ADDENDUM NO. 3, APRIL 30, 2009

RE: Ocean Avenue Elementary School
Portland, Maine
A/E Comm. No. 3316.10

FROM: WBRC Architects-Engineers
141 Preble Street
Portland, Maine 04101
Tel: (207) 828-4511

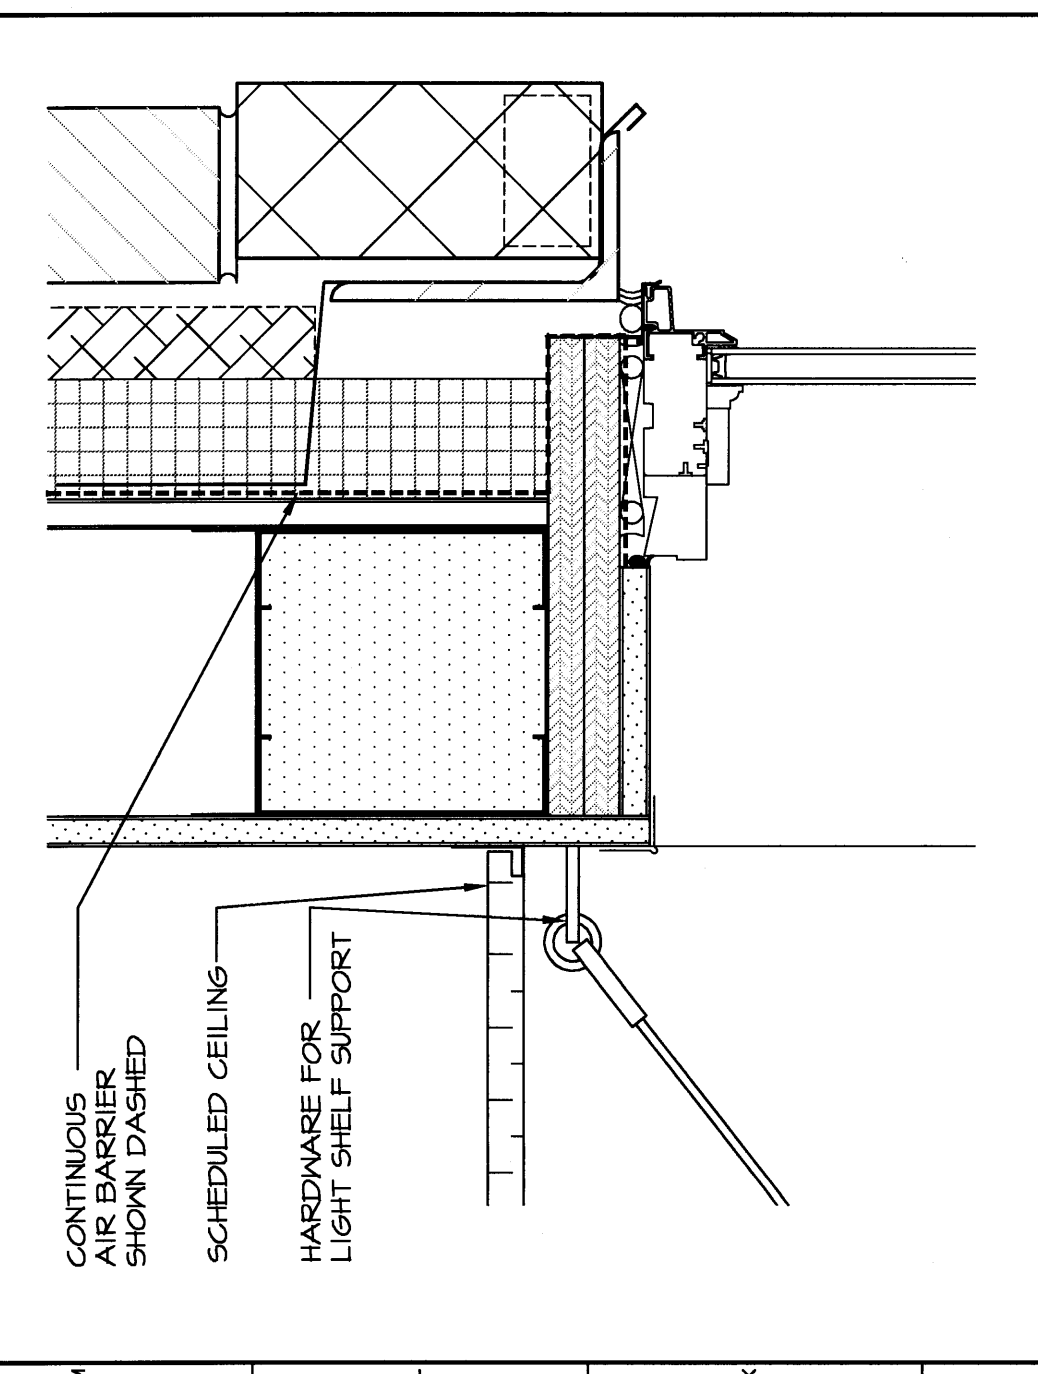
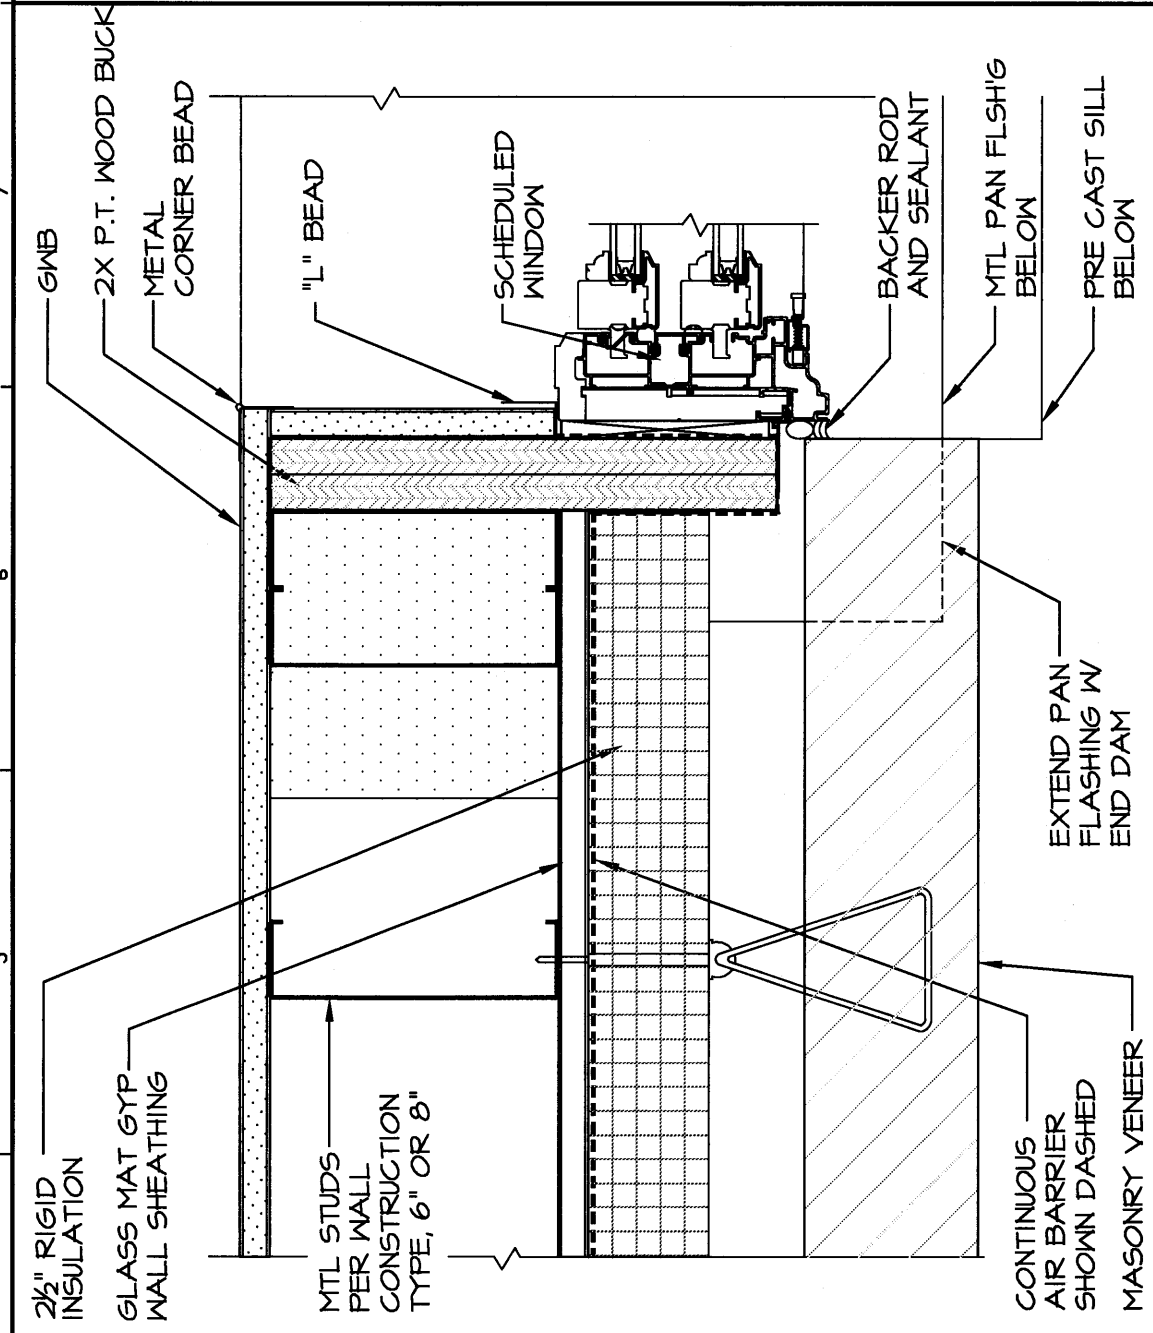
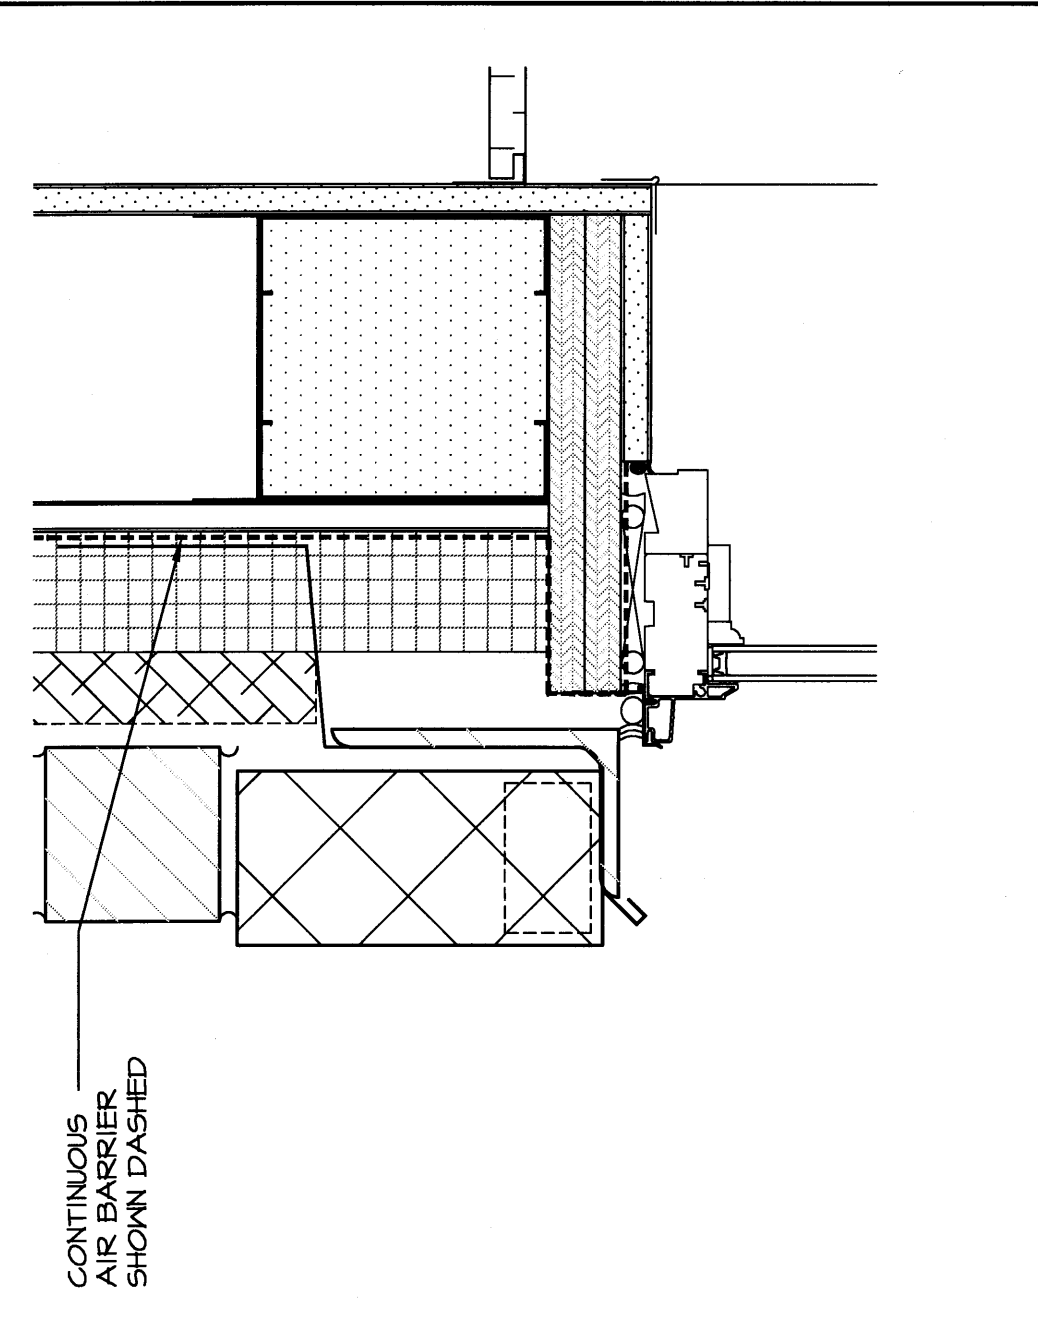
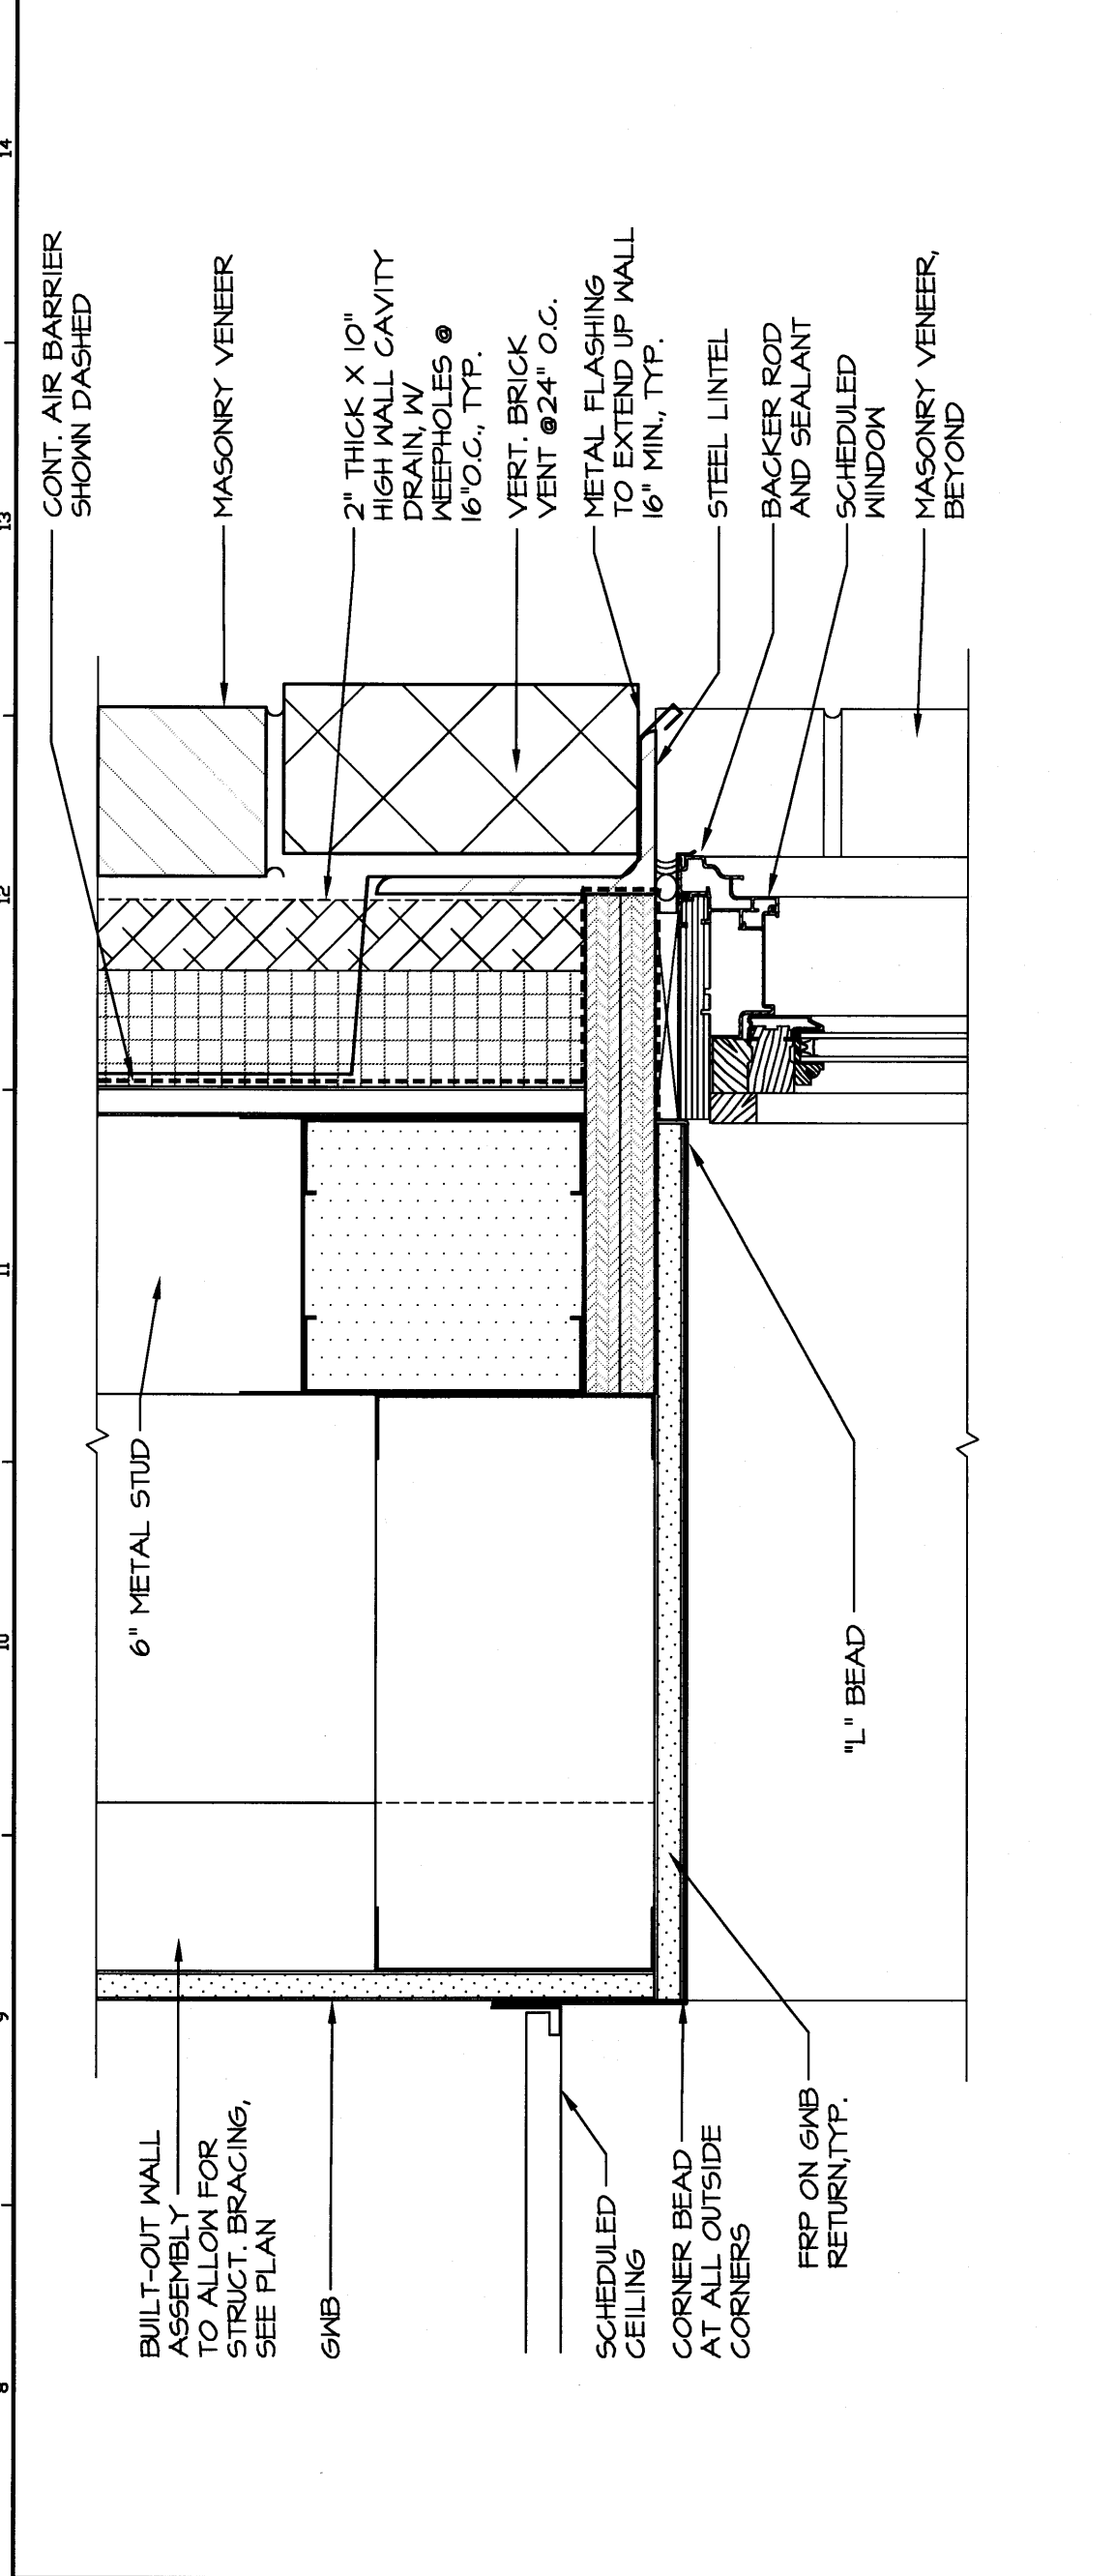
32. Sheet AE508, Window Details, REVISE portions as indicated on Sketch ADD3-AE508-1.
33. Sheet PL601, Plumbing Legend & Schedules, REVISE portions as indicated on Sketch ADD3-PL601-1.
